Appeal Decision

Appeal Ref: APP/R5510/D/22/3311973

236 Woodlands Avenue, Ruislip, Hillingdon HA4 9QY

- The appeal is made under section 78 of the Town and Country Planning Act 1990 against a refusal to grant planning permission.
- The appeal is made by Mr Srujan Yakkati against the decision of the Council of the London Borough of Hillingdon.
- The application Ref 9248/APP/2022/2237, dated 12 July 2022, was refused by notice dated 7 September 2022.
- The development proposed is retention of hip to gable loft and single-storey rear extension as constructed, rear dormer and front porch.

JOB TITLE	
236 WOODLANDS AVENUE EASTCOTE HA4 9QY	
DRAWING TITLE	
AS BUILT ELEVATIONS	DRAWN
DATE JULY 2022	SCALE 1: 100.
DRAWING No.	Size A3
P	06

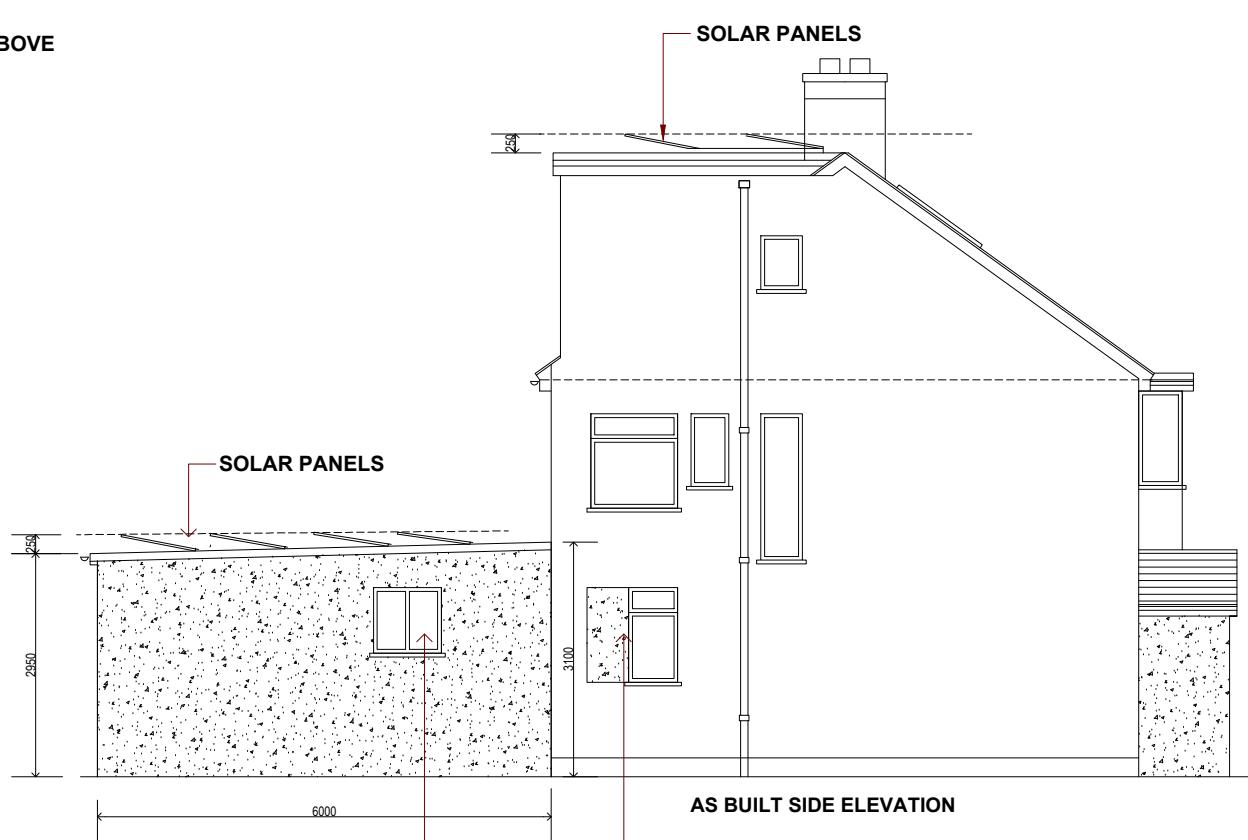
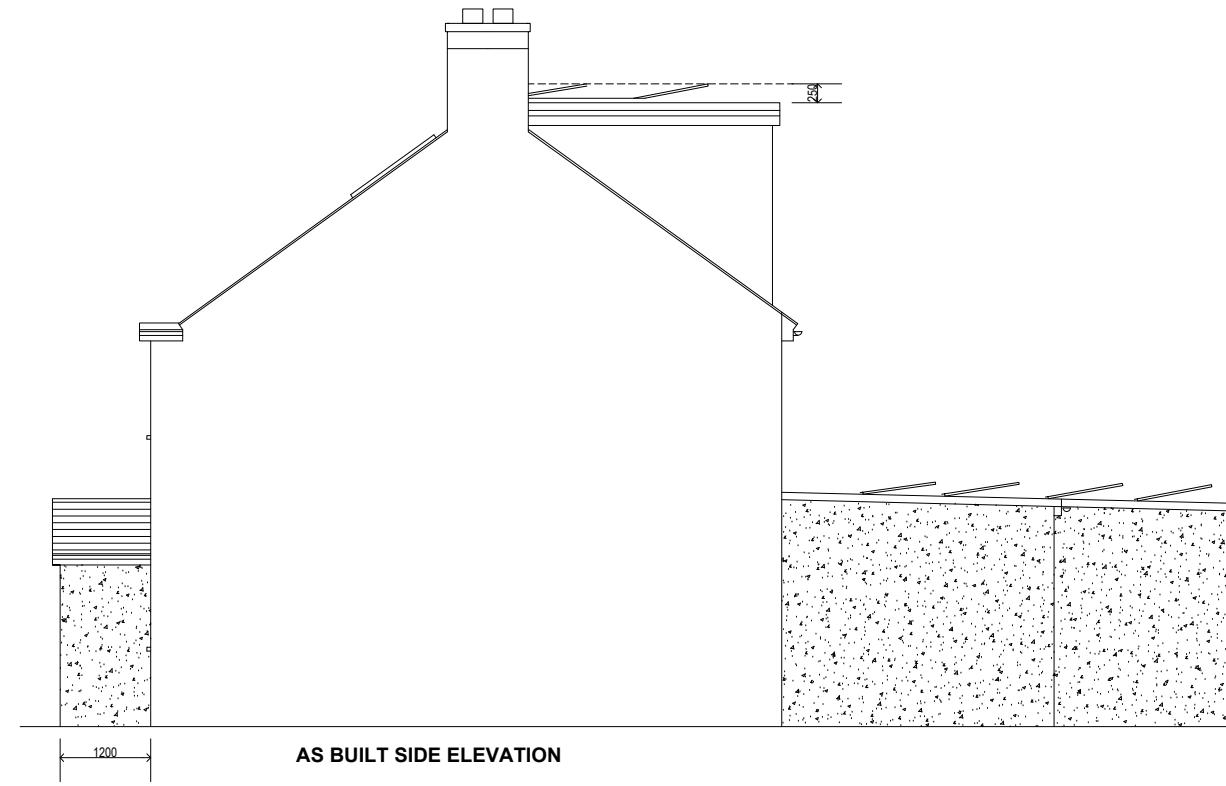
7. The appeal site is one half of a pair of semi-detached houses situated in an established residential area of similar properties.
8. The change from a hipped roof to a gable end on just one side of the building has significantly altered its form and unbalanced the symmetrical relationship of the semi-detached pair. This unfortunate effect is further compounded by a ridge line that is noticeably higher than the adjoining roof and the use of a drastically different slate roofing material rather than matching the existing concrete tiles.

9. Furthermore, the dormer is a bulky structure that occupies most of the extended rear roof slope and is built flush to the gable end with a rendered side that is indistinguishable from the rest of the gable elevation. Its excessive size and box-like form is not in keeping with the form and proportions of the host building and creates the impression of a flat-roofed third storey at the rear.

10. The overall result is a scale and design of development which does not integrate sensitively with the host building, deeply harming its character and appearance.

12. For all these reasons, I find that the hip to gable loft extension and rear dormer unacceptably harms the character and appearance of the host building and its surroundings. In this regard, the proposal is contrary to Policy DMHD1 of the DMP where it states that the Council will not support poorly designed or over-large roof extensions including proposals to convert an existing hipped roof to a gable, nor raising of the main roof above the existing ridgeline of a house, and requires roof extensions to be subservient to the scale of the existing roof, employ matching materials, and to ensure that there is no adverse cumulative impact on the character, appearance or quality of the existing street or wider area. I also find conflict with the more general requirements of Policy DMHB11 of the DMP; Policy BE1 of the Hillingdon Local Plan: Part 1 – Strategic Policies (2012); Policy D4 of the London Plan (2021); and chapter 12 of the Framework, which taken together, require new development to be well designed; respect the design and architectural composition of the original building; harmonise with the local context; and add to the overall quality of the area.

1. The appeal is dismissed in respect of the hip to gable loft and rear dormer extension.
2. The appeal is allowed and planning permission is granted in respect of the single-storey rear extension and front porch at 236 Woodlands Avenue, Ruislip, Hillingdon HA4 9QY in accordance with the terms of the application Ref 9248/APP/2022/2237, dated 12 July 2022, and the plans numbered: P01 and P06 so far as relevant to that part of the development hereby permitted.
